REPORT on the IMPLICATIONS for EUROPEAN SITES

Proposed Beacon Fen Energy Park

Planning Inspectorate Reference: EN010151

08 December 2025

Figure 4.1 Cumulative Development: Nationally Significant Infrastructure Projects

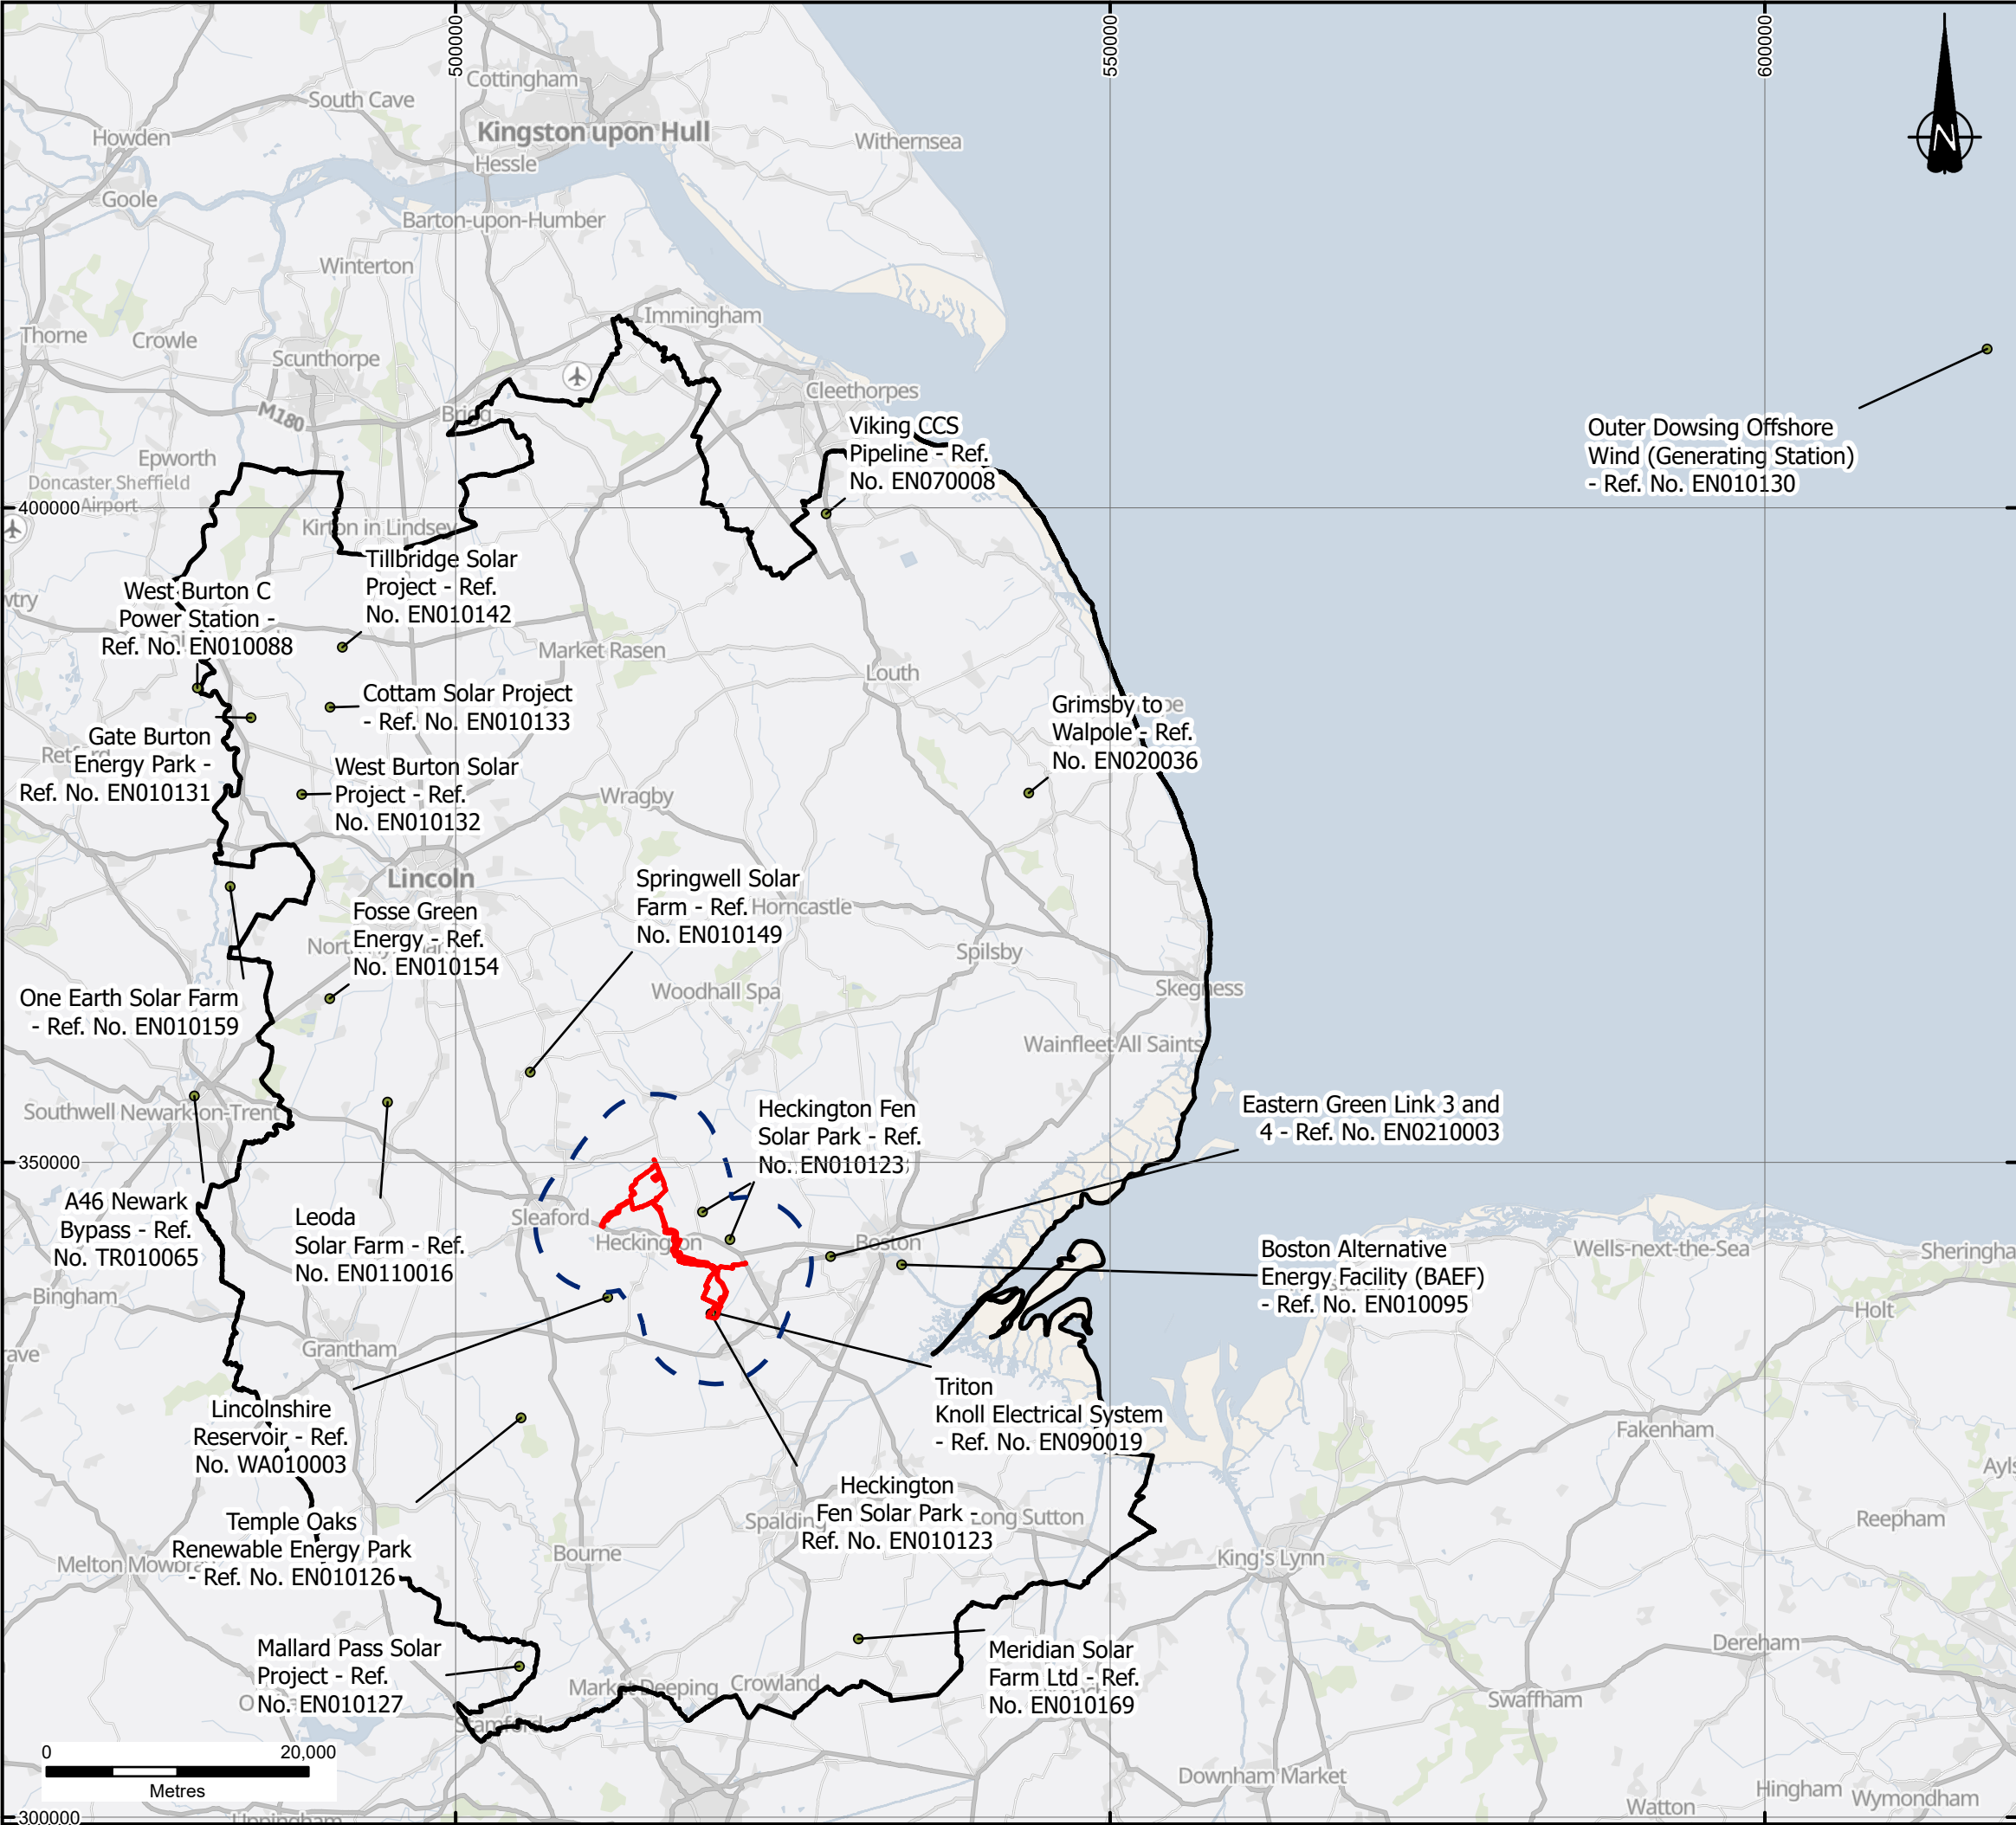
To the applicant, please provide a figure showing the location the projects included in table 5 of APP-050.
